WEST SUSSEX COUNTY COUNCIL CONSULTATION

TO:	Arun District Council FAO:Michael Eastham
FROM:	WSCC - Highways Authority
DATE:	11 August 2020
LOCATION:	Land South of Water Lane Angmering
SUBJECT:	A/109/20/RES Approval of reserved matters following outline consent A/99/17/OUT for 175 No dwellings & associated infrastructure. This application may affect the setting of a listed building, may affect the character & appearance of the Angmering Conservation Area & falls within Strategic Site SD9, CIL Zone 1 (Zero Rated).
DATE OF SITE VISIT:	n/a
RECOMMENDATION:	Modification
S106 CONTRIBUTION TOTAL:	n/a

Drawing No	Revision
A290-RM-701	P3

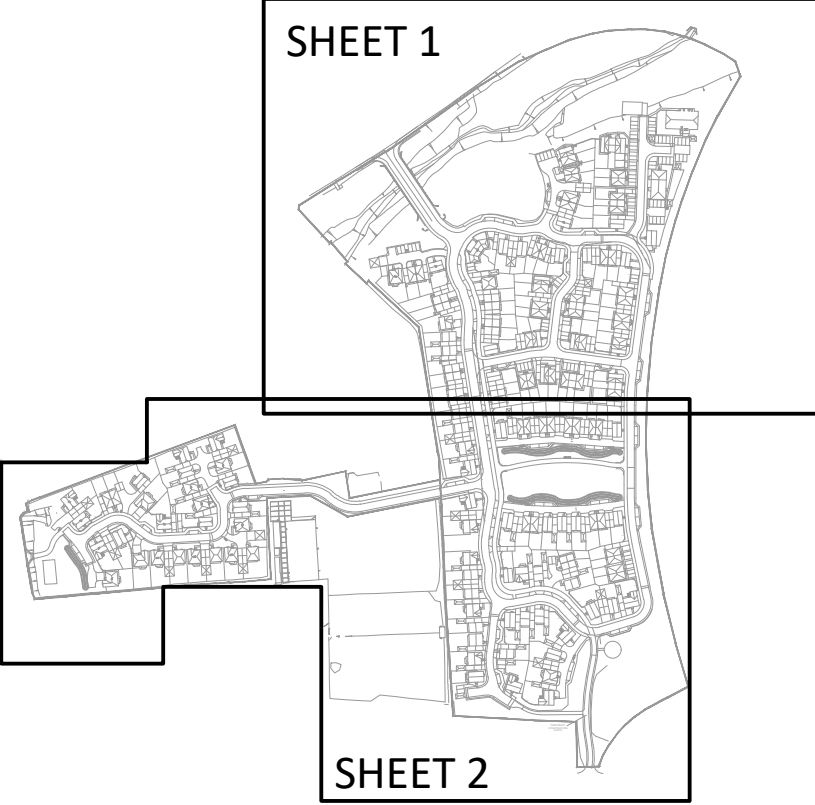
2. Details of materials are provided. These details indicate that certain aspects are to be provided to an adoptable standard. At this stage, WSCC Highways are not reviewing the details in terms of acceptability for adoption as public highway; WSCC Highways are reviewing the details only for their planning acceptability. Materials are not being approved for adoption by WSCC Highways at this stage.

5. A 4.1 metre wide shared surface is also proposed serving plots 50 to 56. Again, 4.1 metres isn't ideal particularly as this is a shared surface with vehicles sharing the same space as pedestrians. Due consideration is though given to this being a short section of road that serves relatively few dwellings, with resultant light traffic flows. The road width here is considered more appropriate. The only comment that would be made regarding this length of shared surfacing is in terms of material. It is standard practice to design shared surfaces with contrasting material to those areas with segregated carriageways and footways. This length of shared surface is however indicated to be surfaced in tarmacadam. The surfacing should be changed to block paving.
